CITY OF ALBUQUERQUE

**Re: APS Emerson Elementary/Kindergarten Addition,
620 Georgia Street SE,
Permanent Certificate of Occupancy – Transportation Development
Engineer's Stamp dated 05-17-11 (L18-D026)
Certification dated 05-18-11**

**Re: Emerson Elementary Kindergarten Add'n Grading and Drainage Plan
Engineer' Stamp dated 11-17-09 (L18-D26)**

**Re: Emerson Elementary Kindergarten Add'n Grading and Drainage Plan
Engineer' Stamp dated 10-2-09 and 10-4-09(L18-D26)**

C104

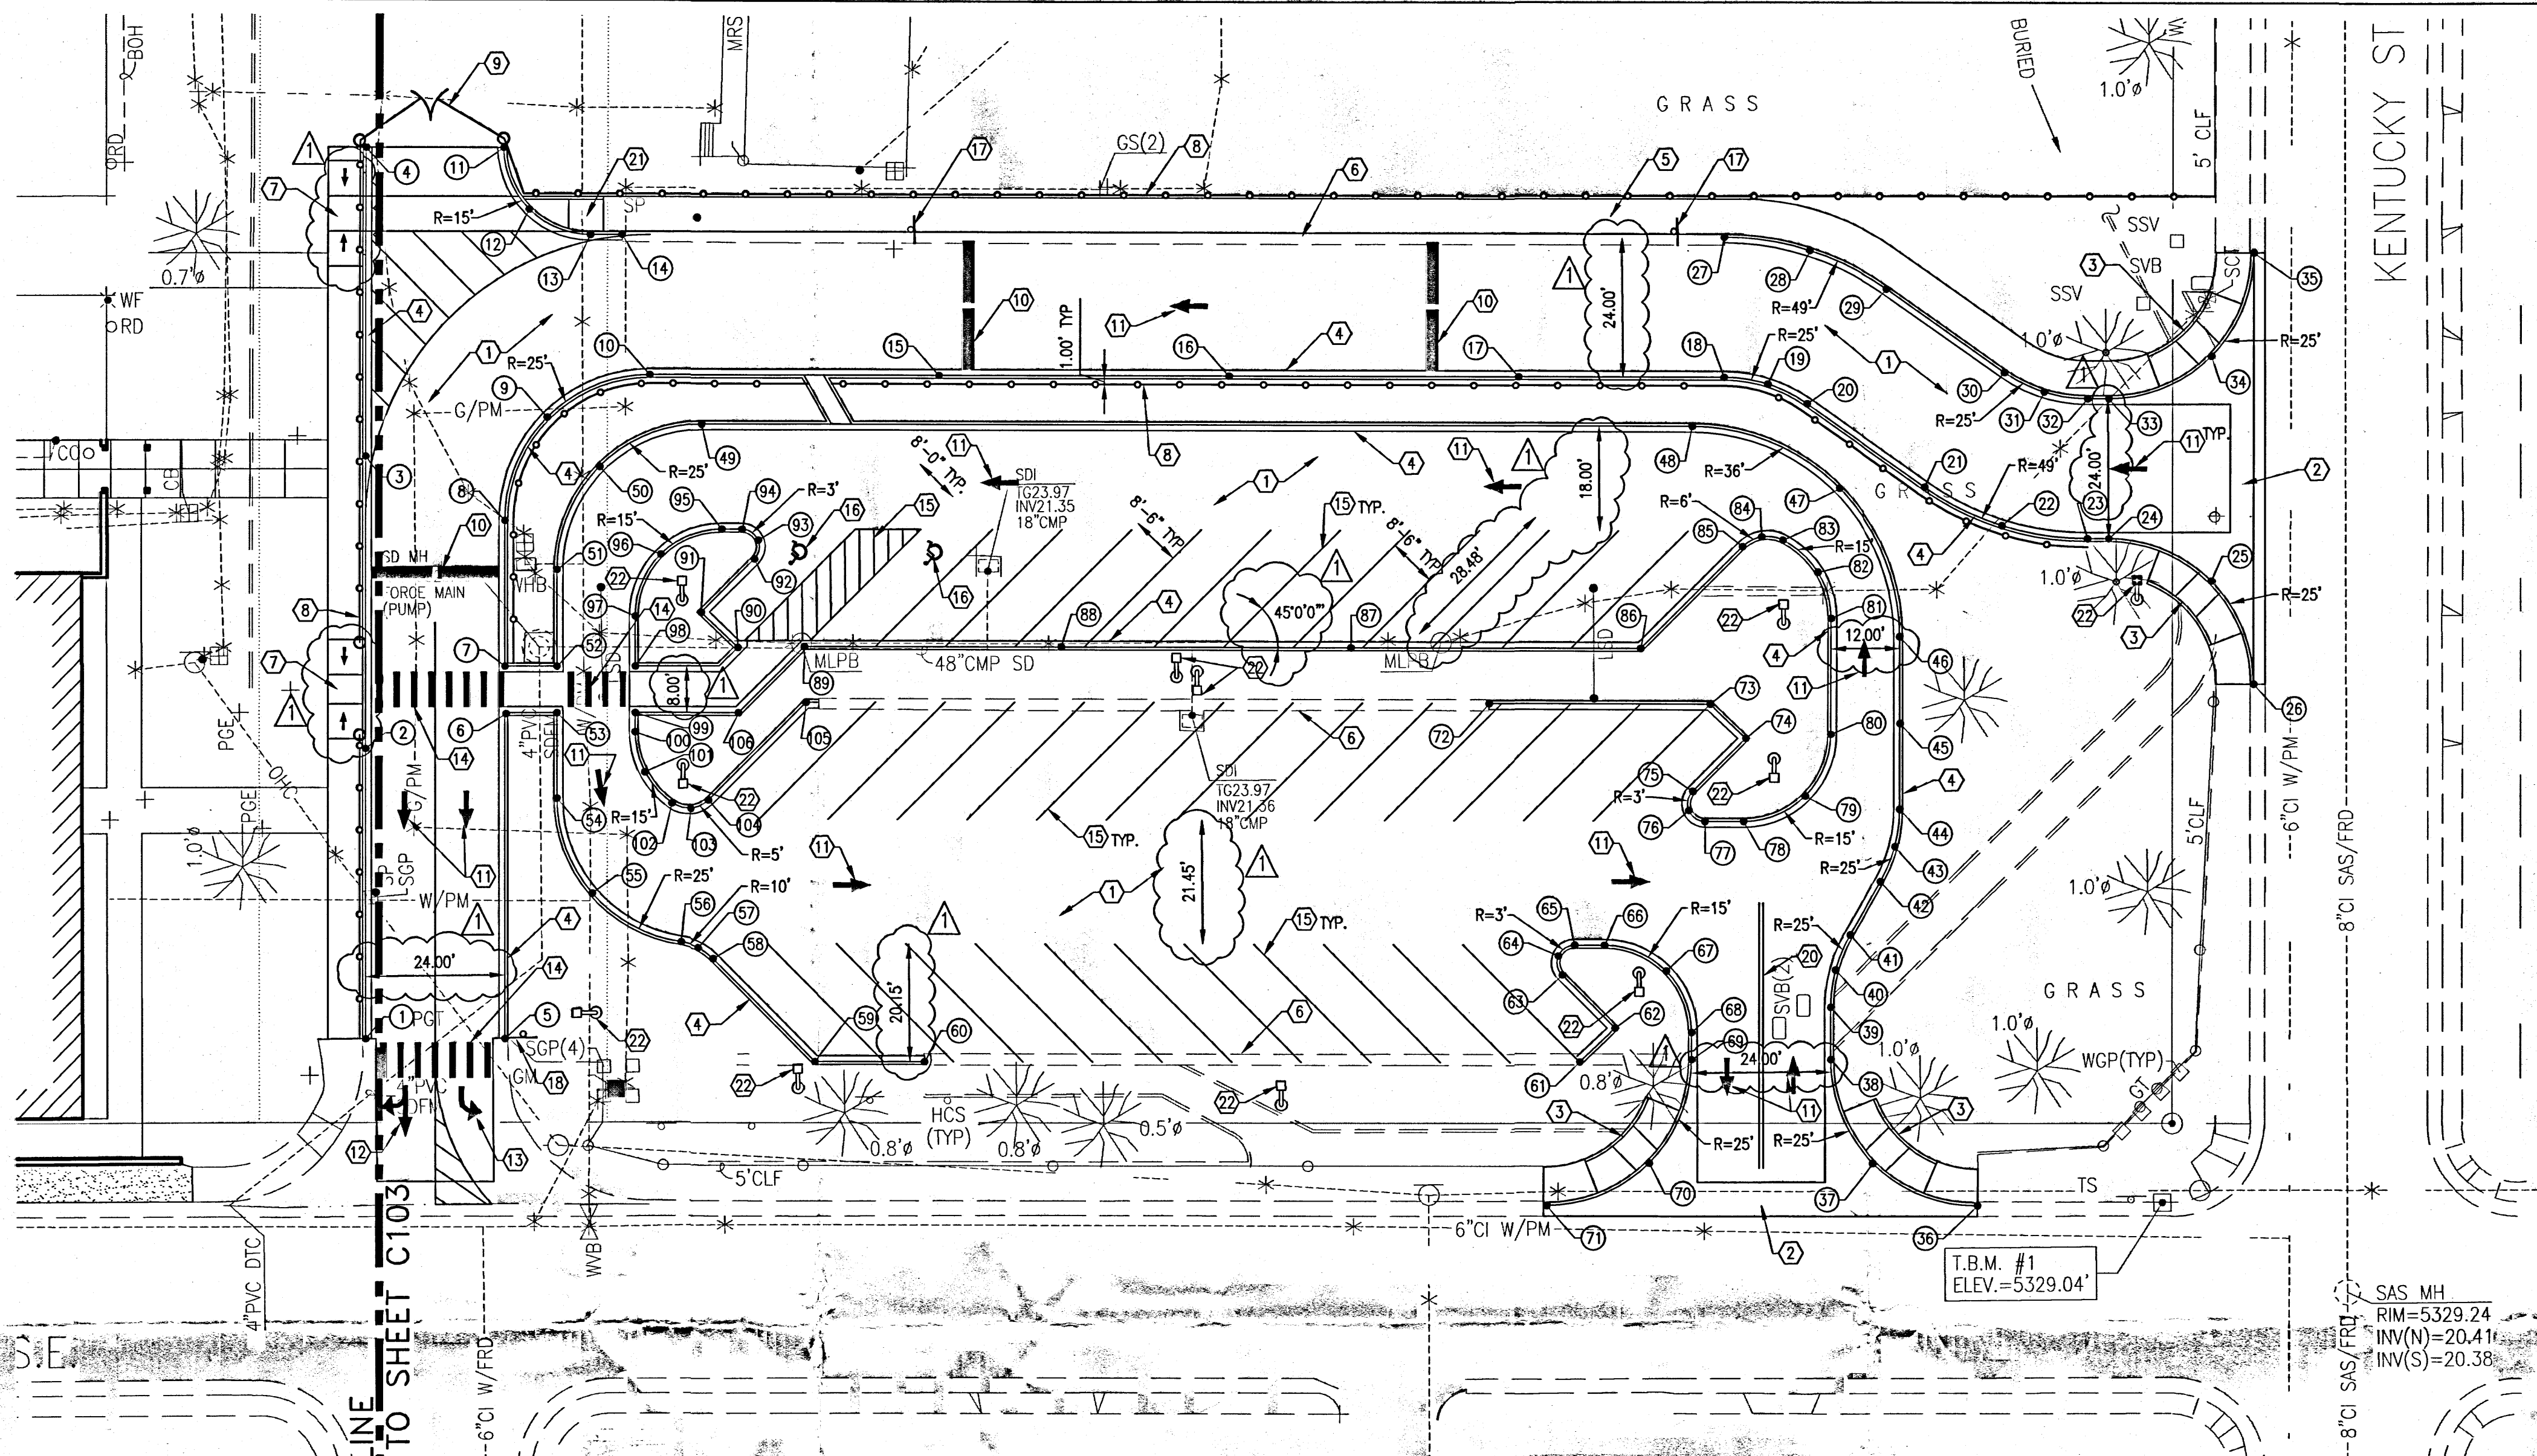
- How wide is the parking lot channel and where are the build notes for it?

- The parking lot channel is 3.5 feet wide and build notes are shown on a parking lot site plan sheet.

C501

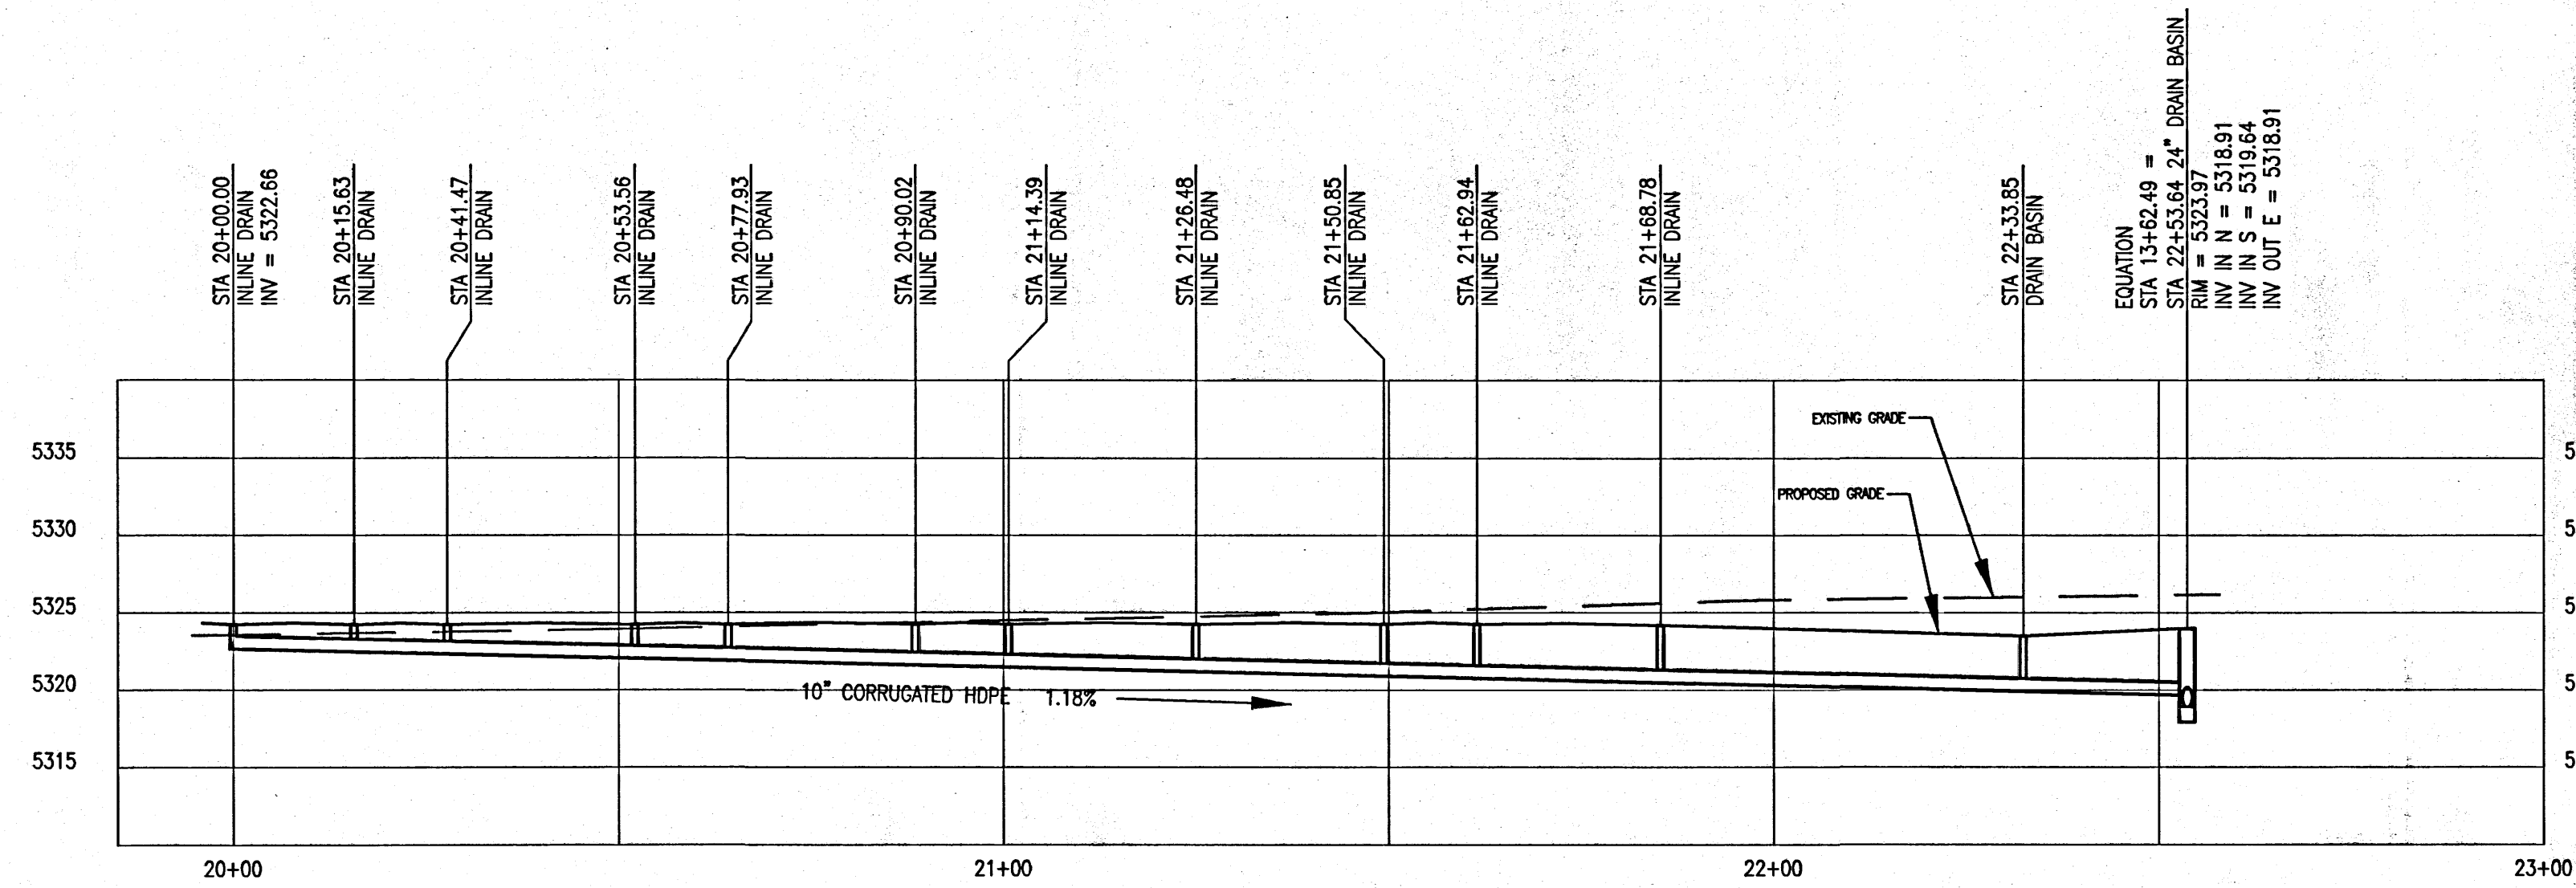
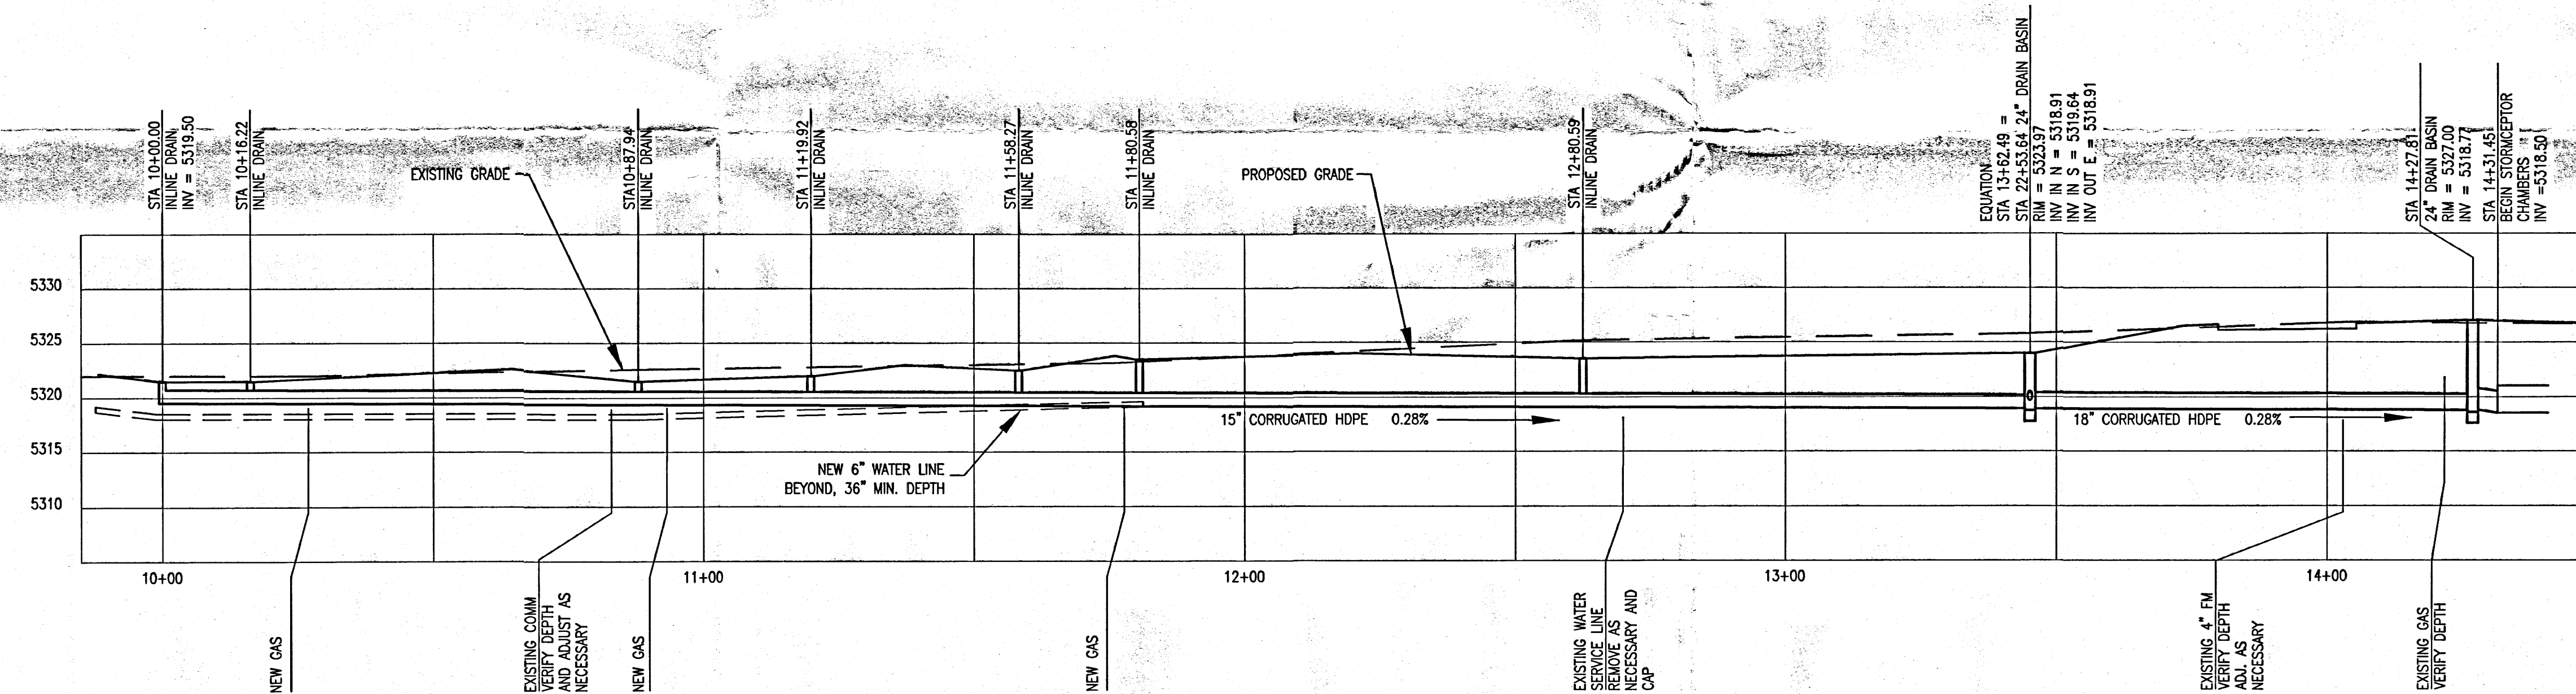
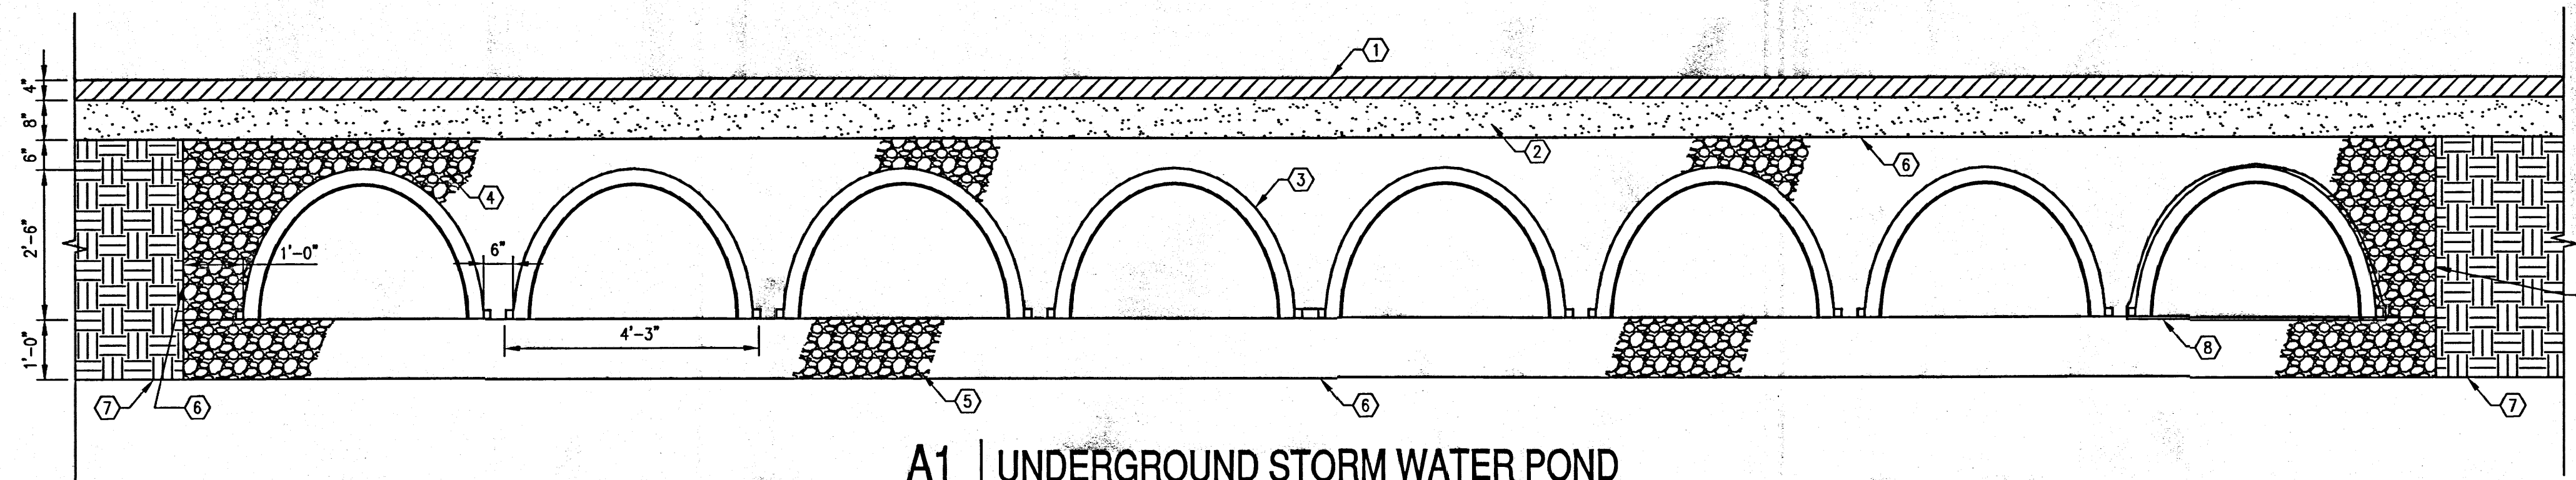
- Is the existing pump working? My information is that the pump needs to be replaced with a duplex type pump.
- Please provide invert elevations for all new piping, new inlets or provide sheet C501.

- According to APS maintenance staff, the pump is working. APS will replace the pump as needed.
- A copy of sheet C501 is provided for your reference and information.
